KITITAS COUNTY

MEMORANDUM

TO: All Staff
FROM: Public Works Plan Review Team
DATE: April 5, 2022
SUBJECT: SX-22-00007 Chappelle

Public Works has reviewed the Shoreline Exemption Application. Please see comments below:

**BOUNDARY AND TOPOGRAPHIC SURVEY  
LOT 5, ELK MEADOWS PARK NO. 2**

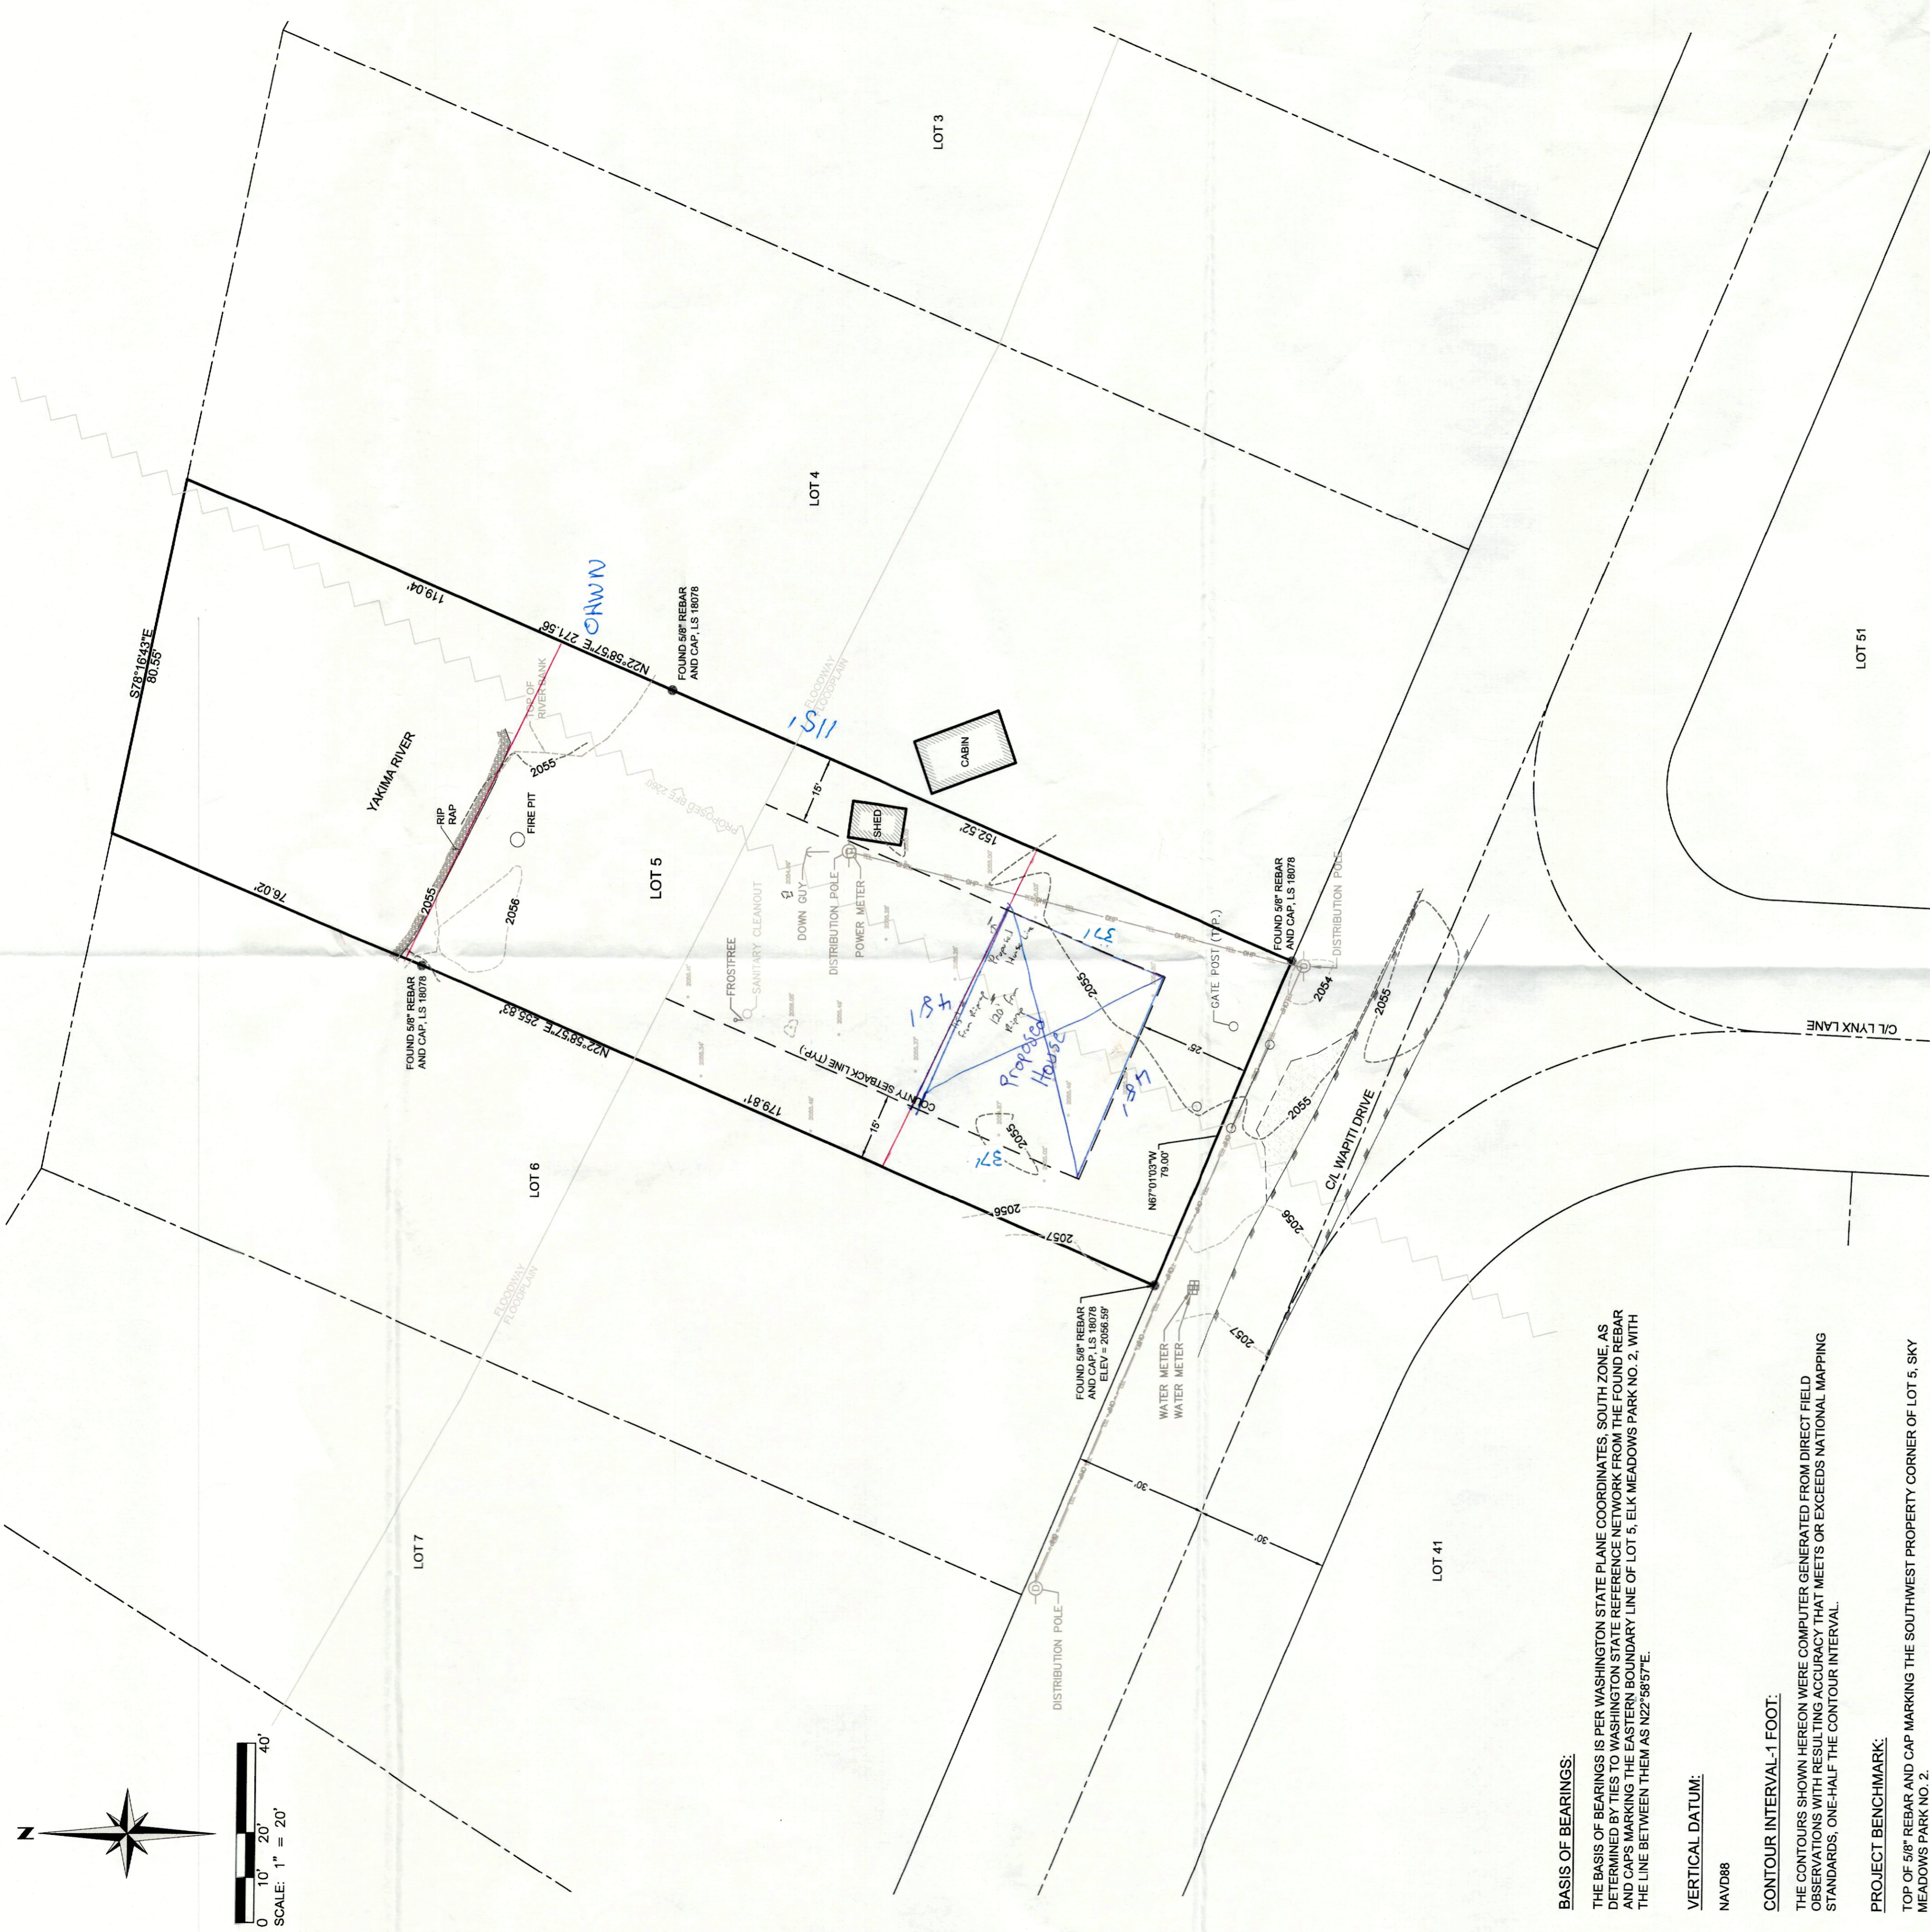
The parcel contains FEMA designated Floodway. Per the submitted site plan, the proposed single-family residence is located outside the Floodway. Please be advised that the Floodway is highly restricted and any development within the floodway must be permitted through a floodplain development permit and must demonstrate no rise of 100-year flood elevations before being permitted. No new or substantially improved residences are allowed within the Floodway.
